SUBJECT: Engineering Review Comment
Mountain View Electric Association Inc. (MVEA)

Project Name: Rolling Hills Ranch North Filing 1 at Meridian Ranch – Final Plat
Project Number: SF2411

S0013'03"E 769.32'

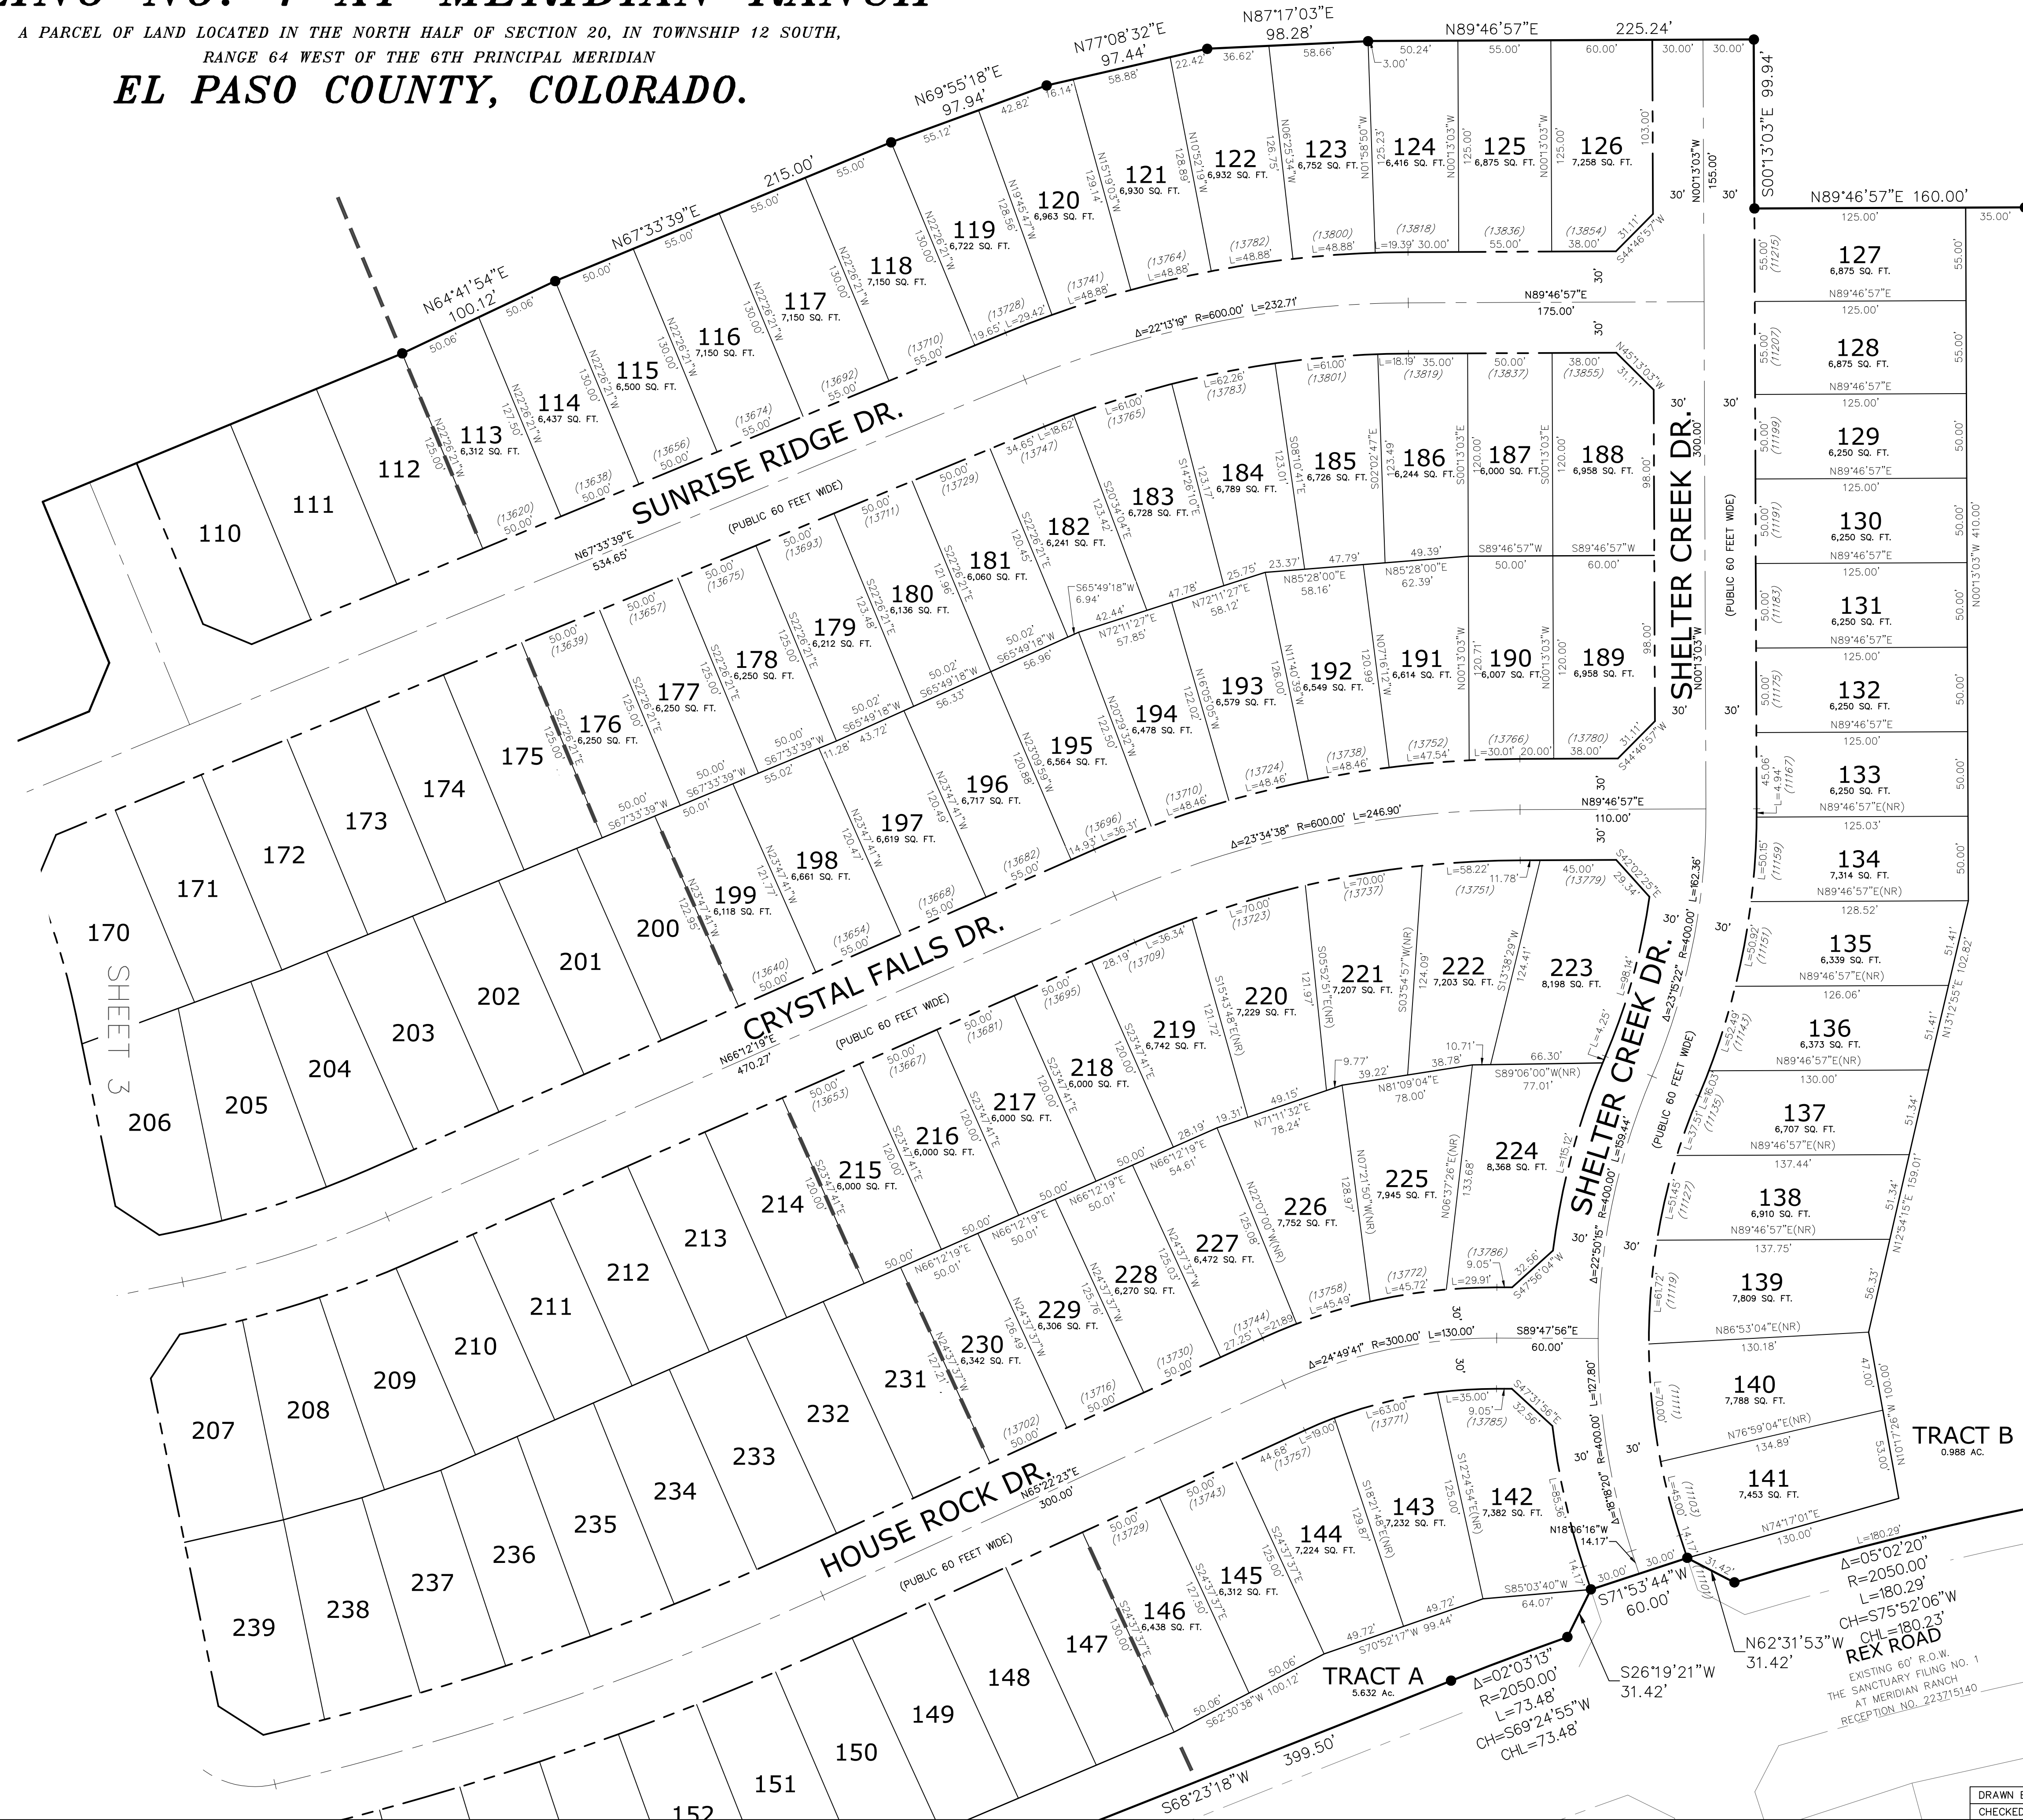
MVEA requests a ten (10) foot front lot utility easement, in addition to any public improvement easements, a five (5) foot side lot utility easement, and a seven and a half (7.5) foot rear lot utility easement along with a twenty (20) foot exterior utility easement on the plat and all tracts include easements. MVEA also requests the platting of MVEA's existing facilities with easements on the plat. Additional easements may be required.
